From:
Sent: 07 April 2025 14:24
To: DC Admin
Subject: Planning Application 2025/90278. Objections

We refer to the above planning application (Erection of stable block (within conservation area) by K Hosker and would ask that the following observations that form my objections to the proposal be considered when deciding the merits of the application. We have no objection to my details being made known to appropriate parties in the process.

title General arrangement as proposed
number 24074D-02-P04
scale 1:100
size A2

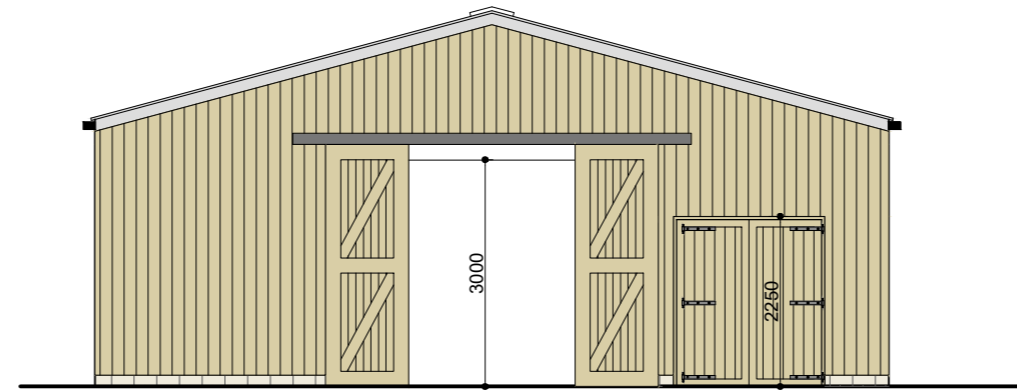
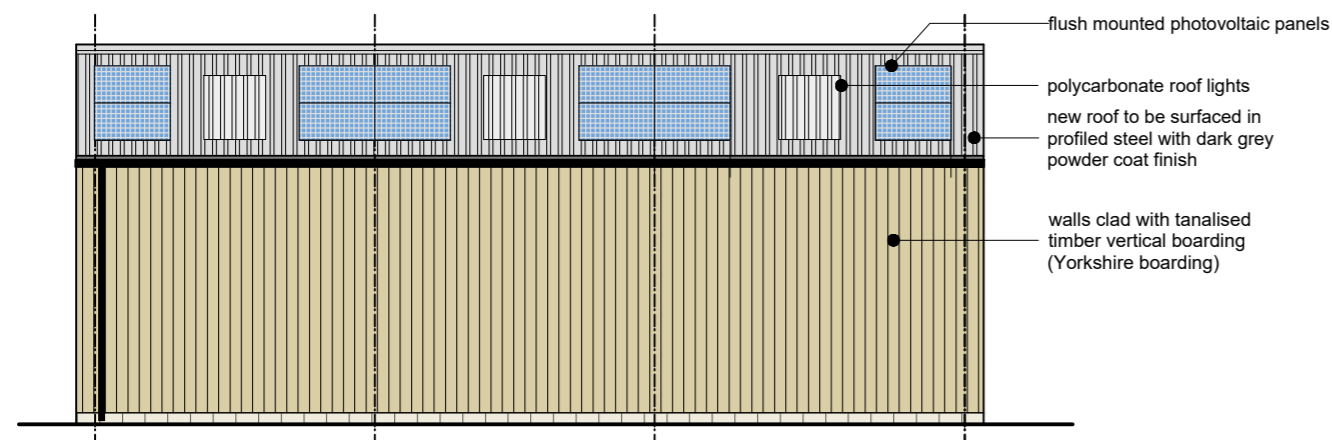
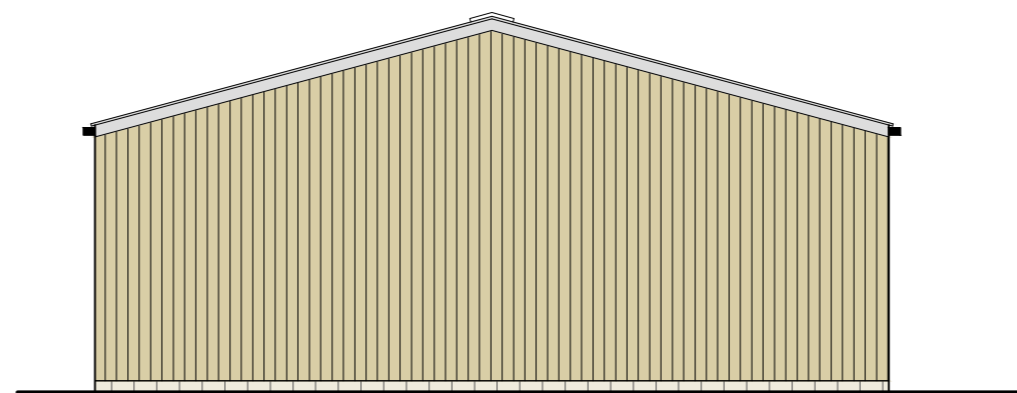
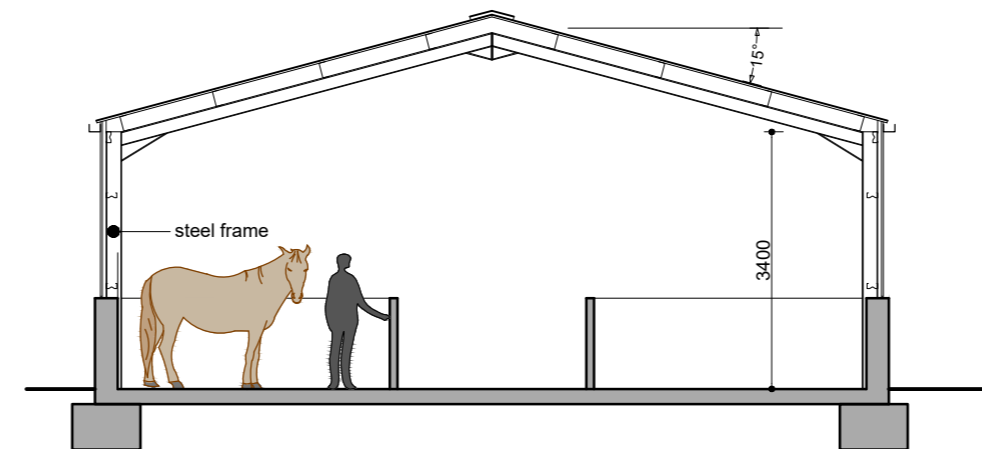
The structure is approximately 45 ft by 50ft. (15000 x 13700) approx 2,250sq ft. While not stated, the application is in fact for stables in the American Barn Style. This is not a traditional style and does not as claimed

In short, the aesthetics are not traditional to Yorkshire (the clue is in the name, notably missing from the application).

Some 58 solar panels are shown in the roof of the American barn. This is a huge number and far exceeds any needs of the proposed structure itself, unless they are the real reason for its size. It is impossible to understand how they help the American Barn blend harmoniously with the green belt, conservation area and numerous listed buildings in the village.

ground floor plan

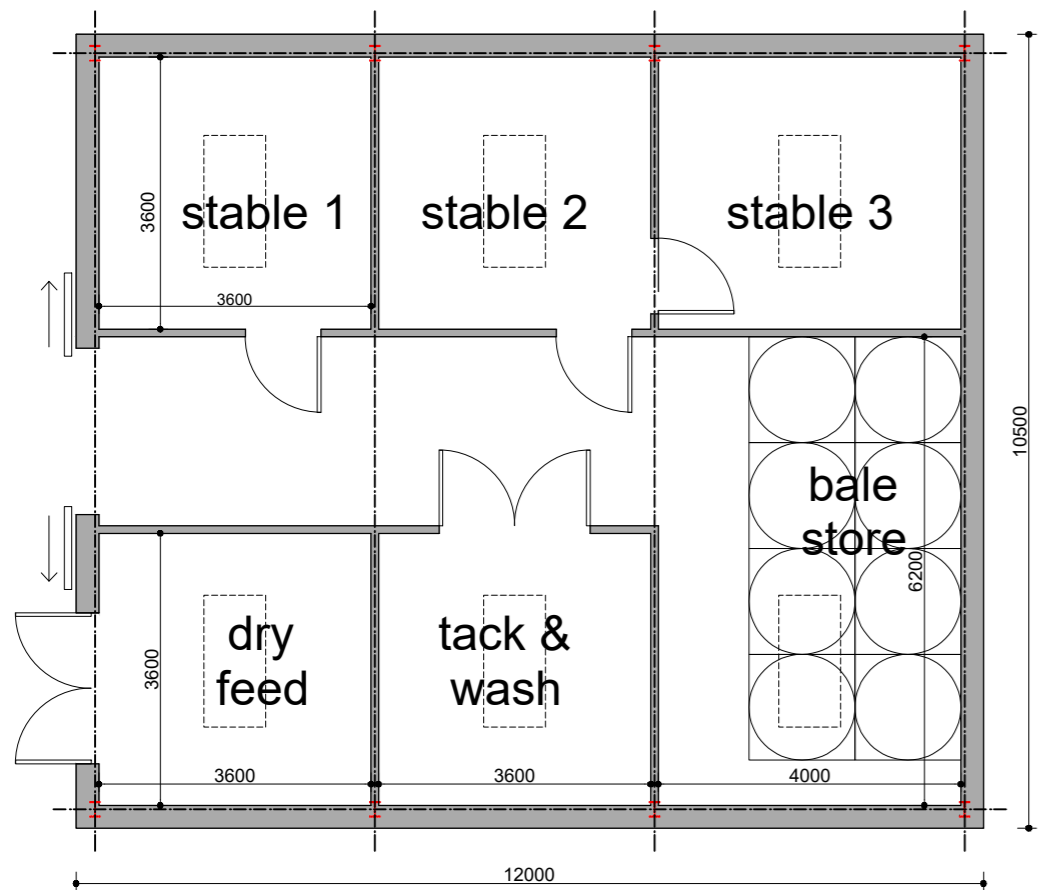
The proposed stalls are 15ft by 15ft (225sq ft). The dimensions again call into question the overall size and scale of the proposal. Despite the huge size, the layout is so poor that stable 3 can only be accessed through stable 2. This is a ridiculous arrangement found in no advertised barn of any size.
